Re. Permit # SFD-2002-0016
90 Kotata Ave
Bunn Level, NC

On April 14, 2020 I made an onsite visit to 90 Kotata Ave located in Bunn Level, North Carolina. The purpose of this visit was to inspect the existing footing for the proposed house. The Footing was excavated approximately 12" below the plan excavation and had a soil bearing capacity over 3000 PSF. (See attached sheet) I will recommend the area below the footings be backfilled with # 57 stone.

CONE PENETROMETER TEST RESULTS
90 KOTATA AVE
BUNN LEVEL, NC

**STEM WALL FOUNDATION Detail** not to scale

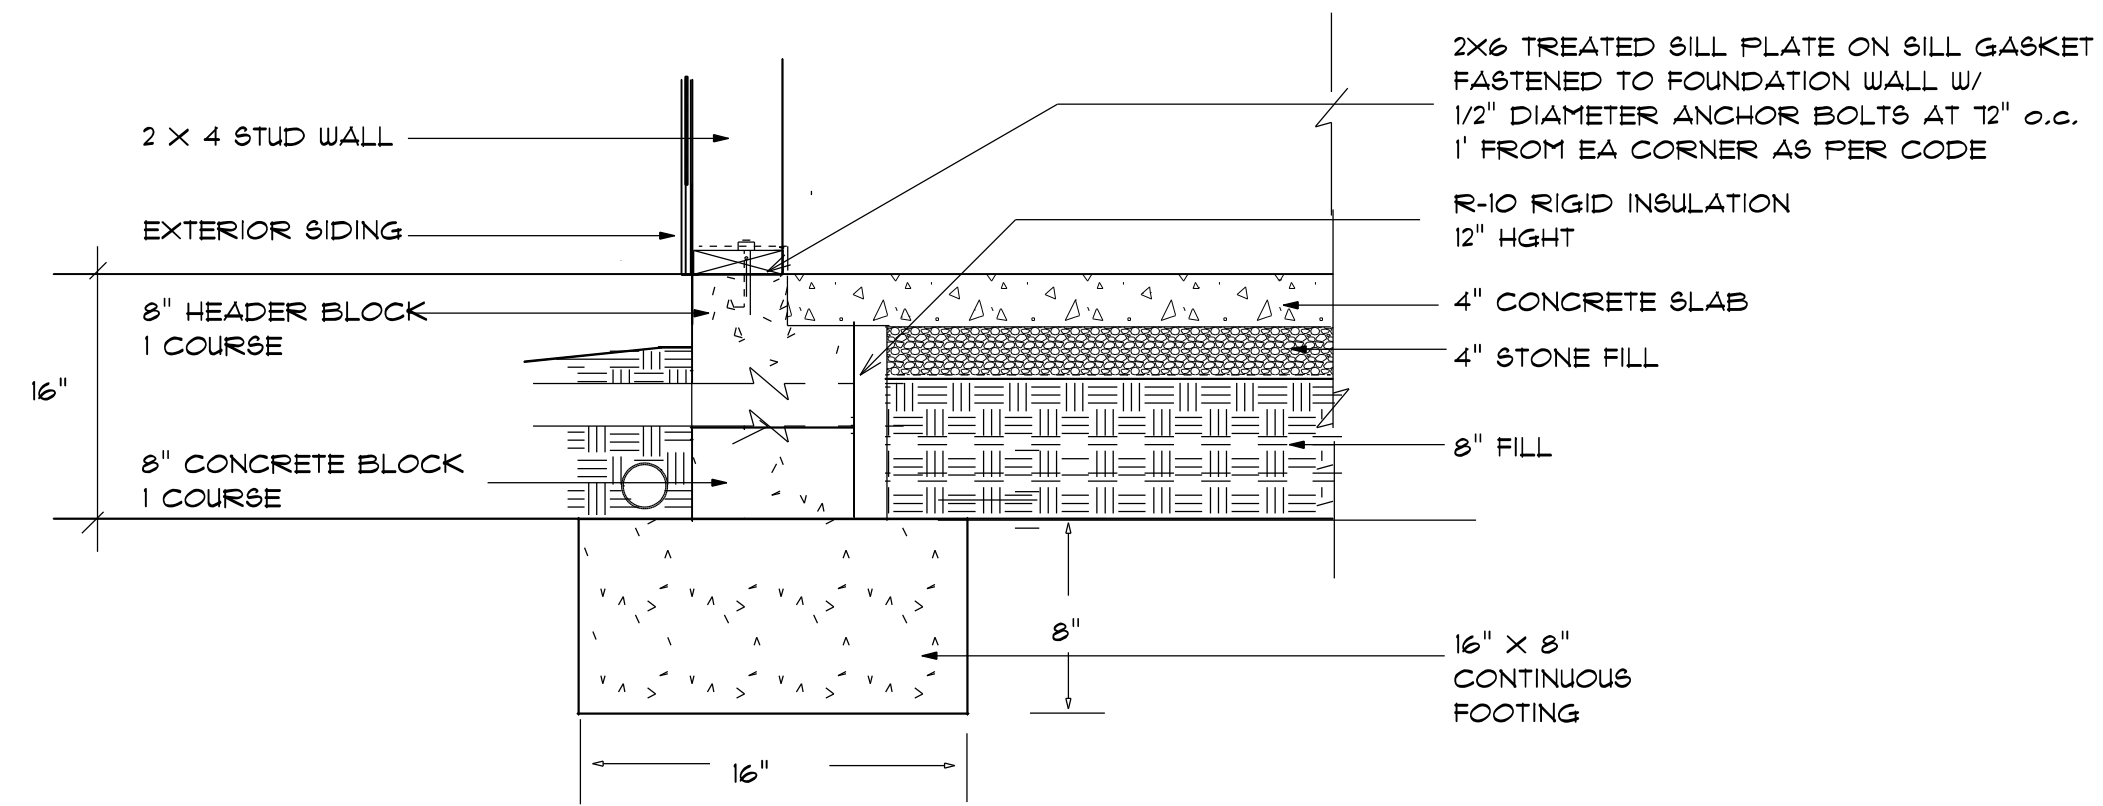
** ADD 12" #57 STONE BELOW FOOTING
